From: Amanda Scholes on behalf of Planning.Responses
Sent: 02 December 2020 11:02
To: Planning Scanning
Subject: FW: Land at Stakers Farm, Yapton - Y/71/20/RES & Y/72/20/RES

From: Simon Davis <Simon.Davis@arun.gov.uk>
Sent: 01 December 2020 12:02
To: Planning.Responses <Planning.Responses@arun.gov.uk>
Subject: FW: Land at Stakers Farm, Yapton - Y/71/20/RES & Y/72/20/RES

Further Drainage Engineer Consultation Comments

INFILTRATION BASIN WITH INFILTRATION BLANKET BENEATH

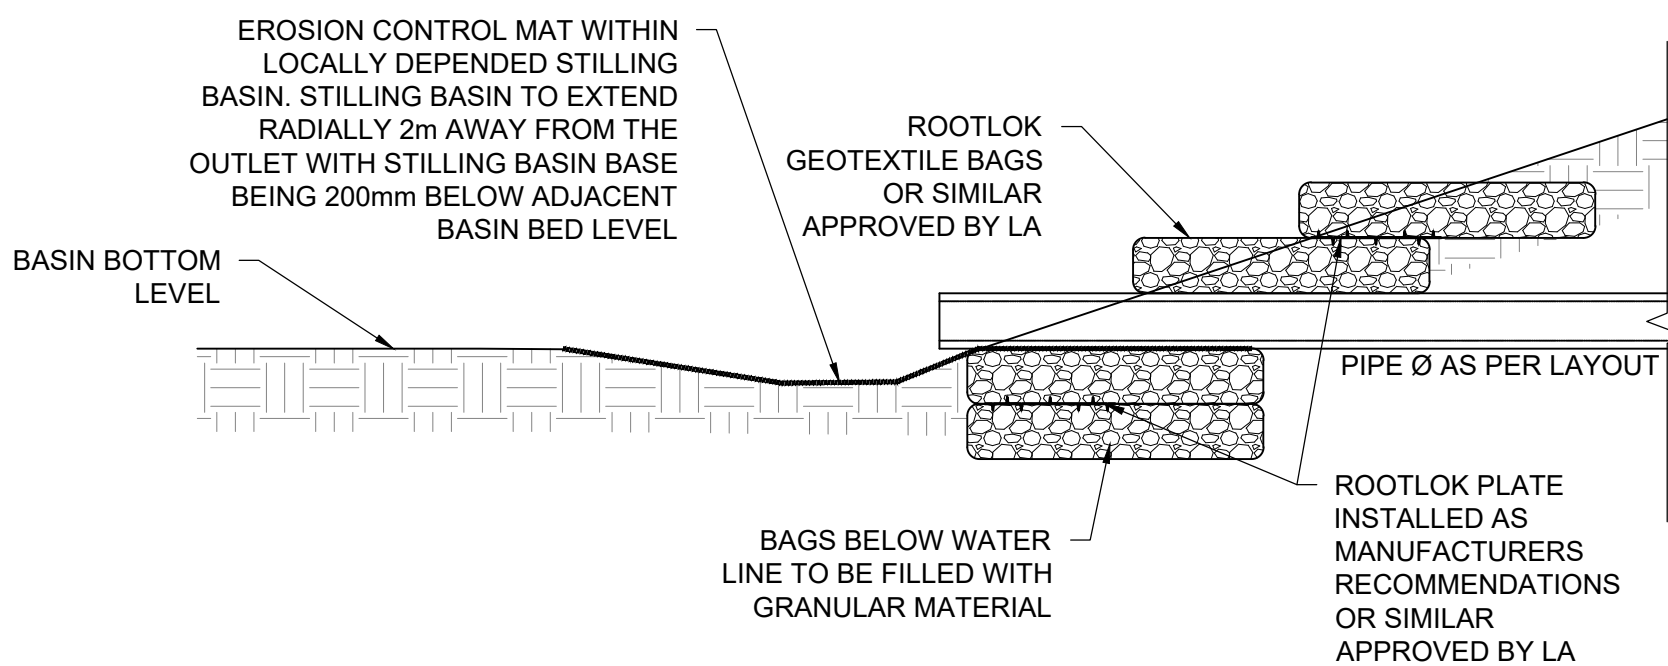
I do recall agreeing the half drain time to be achieved must accommodate the 1 in 10 year storm event as a minimum, as they were having difficult achieving the 1 in 100 event + CC. I may have forgotten to say that climate change allowance needs to be added to the 1 in 10 year event too but I thought that would have been obvious.

I assume they are now having difficulty accommodating the climate change allowance for the 1 in 10 event?

Dandara's first contact with ADC Engineers with specific reference to this scheme occurred over a year ago on 1st November 2019 and discussions around the parameters of design have continued since. The proposals as submitted accord with clearly stated principles. On 17th March 2020 Arun's Principle Engineer wrote, *'You would need to satisfy the half emptying for the 10 year storm. The same applies to the 1 in 100 year + 40% storm.'* On 24 September 2020 he confirmed, *'half emptying on the 1 in 10 yr event must be achieved as a minimum.'*

STORM SEWER DESIGN by the Modified Rational Method

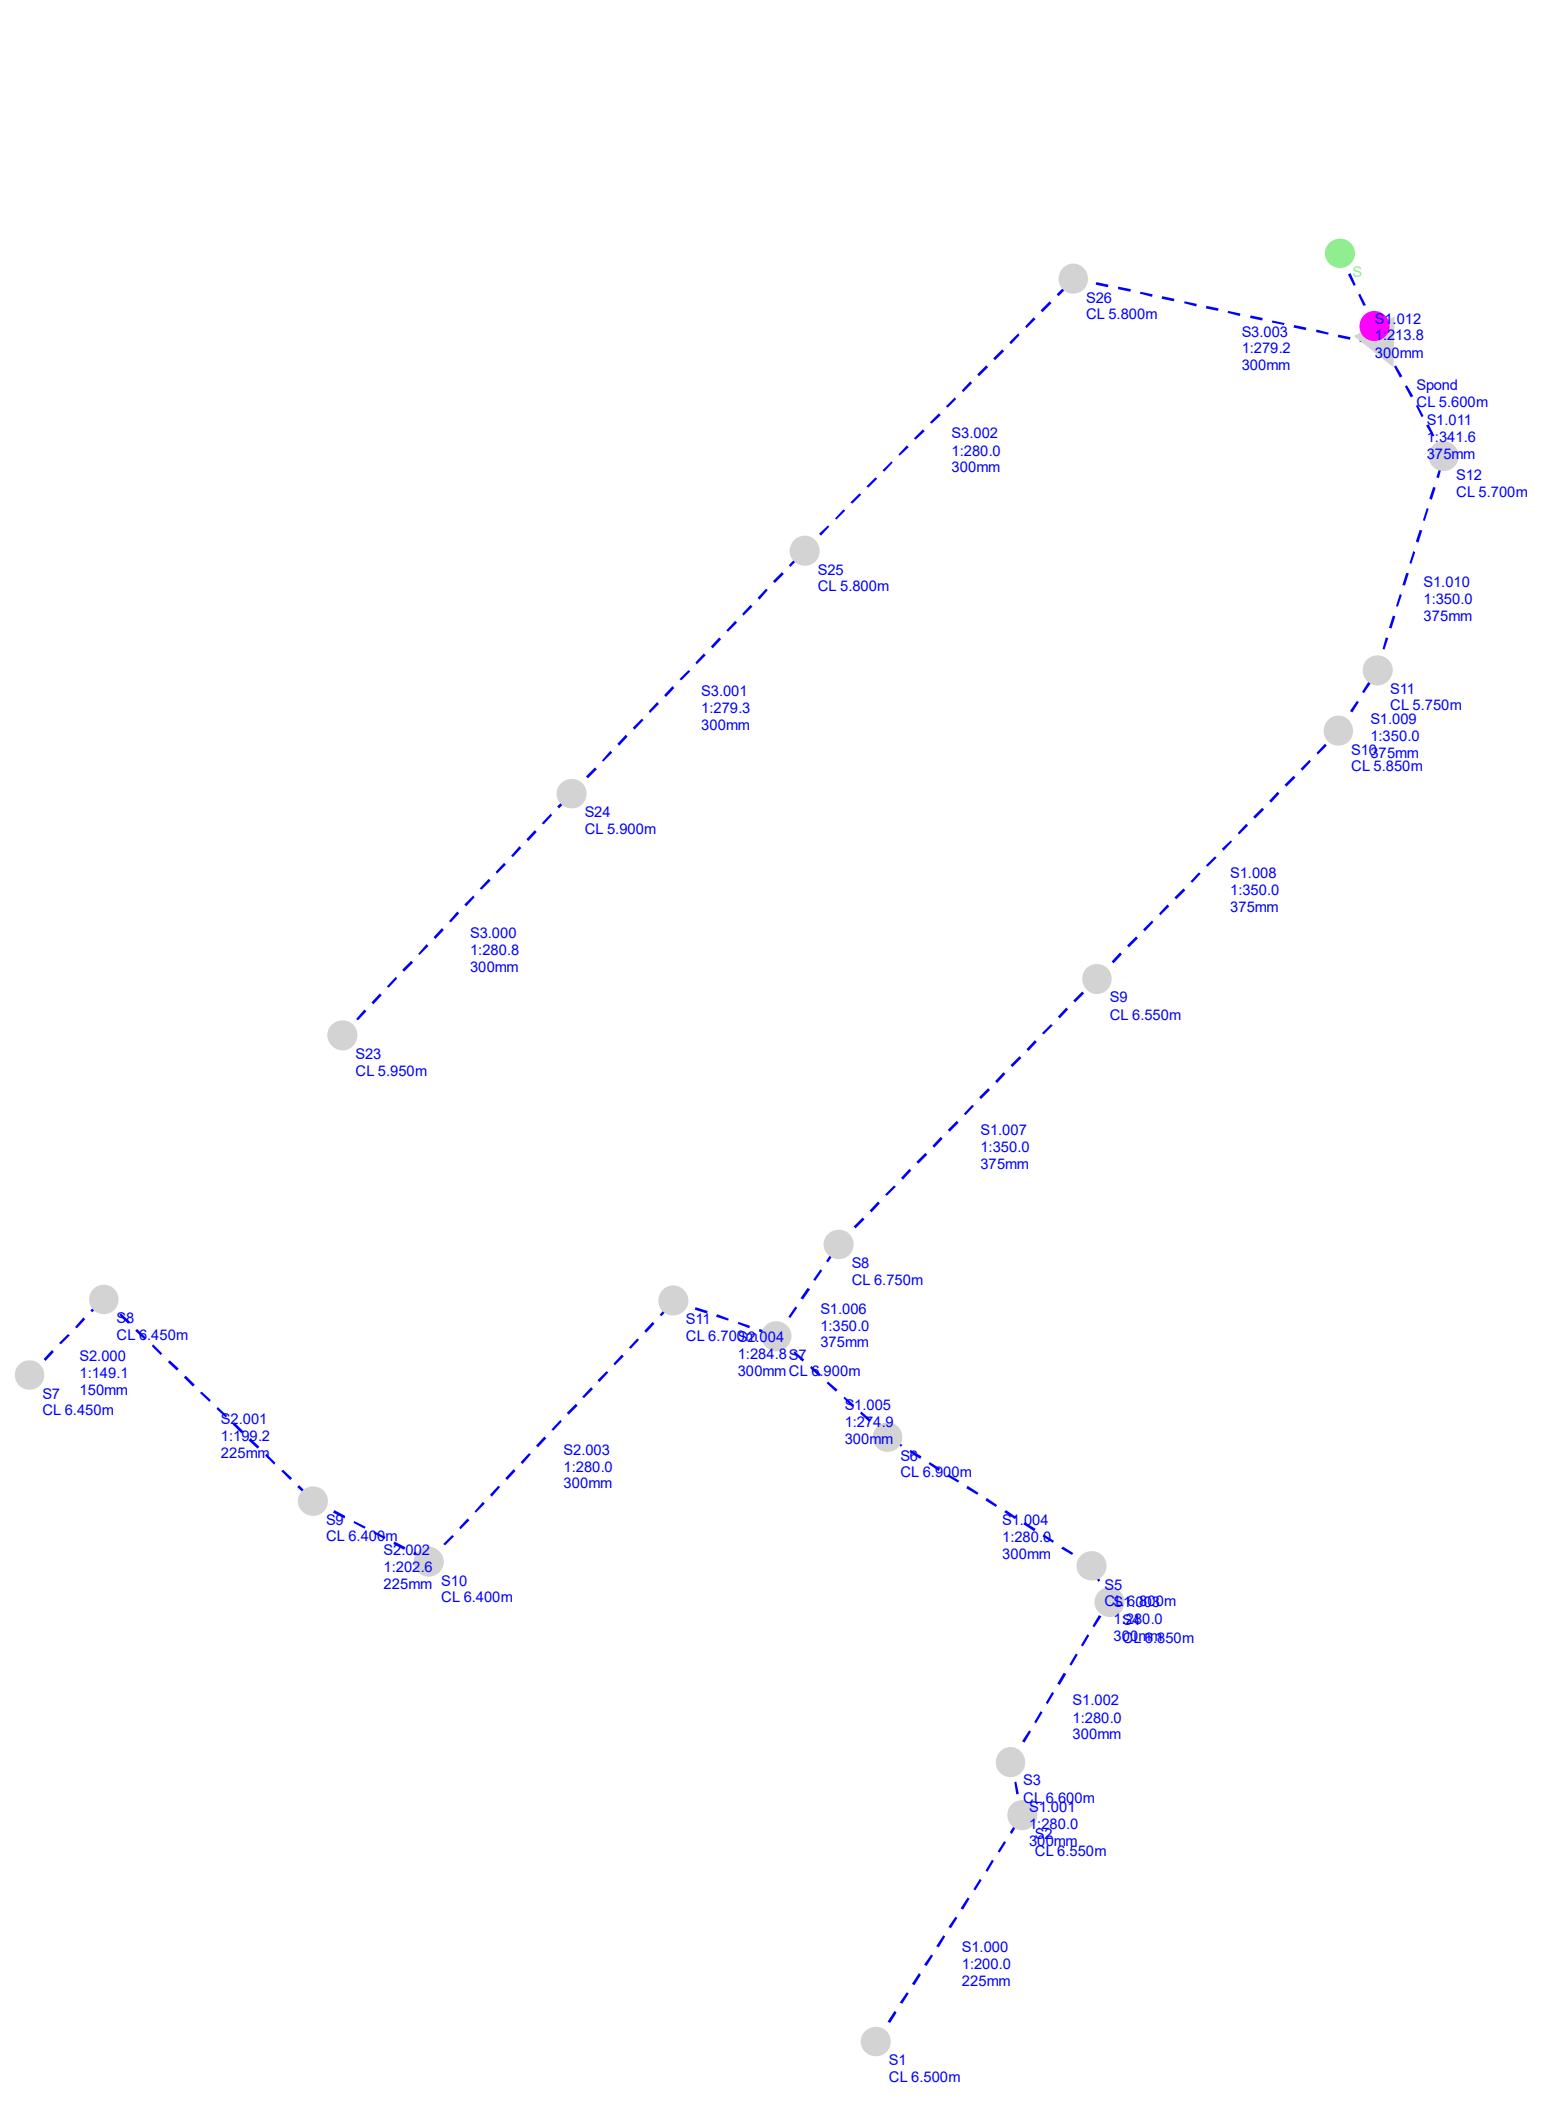
Pagham Application- I took this application on part way through and my remit was to close out the comments already raised. Furthermore, the pipe with the velocity referred to was not at full bore in calculations, a review of hydraulic properties tables demonstrates that the designed pipe does achieve 1m/s at full bore. The same can be said about the other pipes in the calculations.

Angels Nursery- the calculations on the system are not the latest calculations, pipe velocities were greatly improved. And again, based upon hydraulic properties tables minimum falls are provided.

We would recommend that the applicant should achieve pipe velocities of 1m/s at full bore. If they cannot achieve this and have done all that they can to achieve this we will take a further view on this matter but the vast majority of pipes must achieve 1m/s.

Application references BN/30/20/DOC & P/62/20/DOC are recently approved Arun schemes, the first proposes velocity of 0.49m/s, the second velocity of 0.25 m/s. The lowest velocity proposed here is 0.82m/s. Proposals are reflective of principles the Council have found acceptable elsewhere. However and if necessary we are able to amend proposals to meet 1m/s velocity.
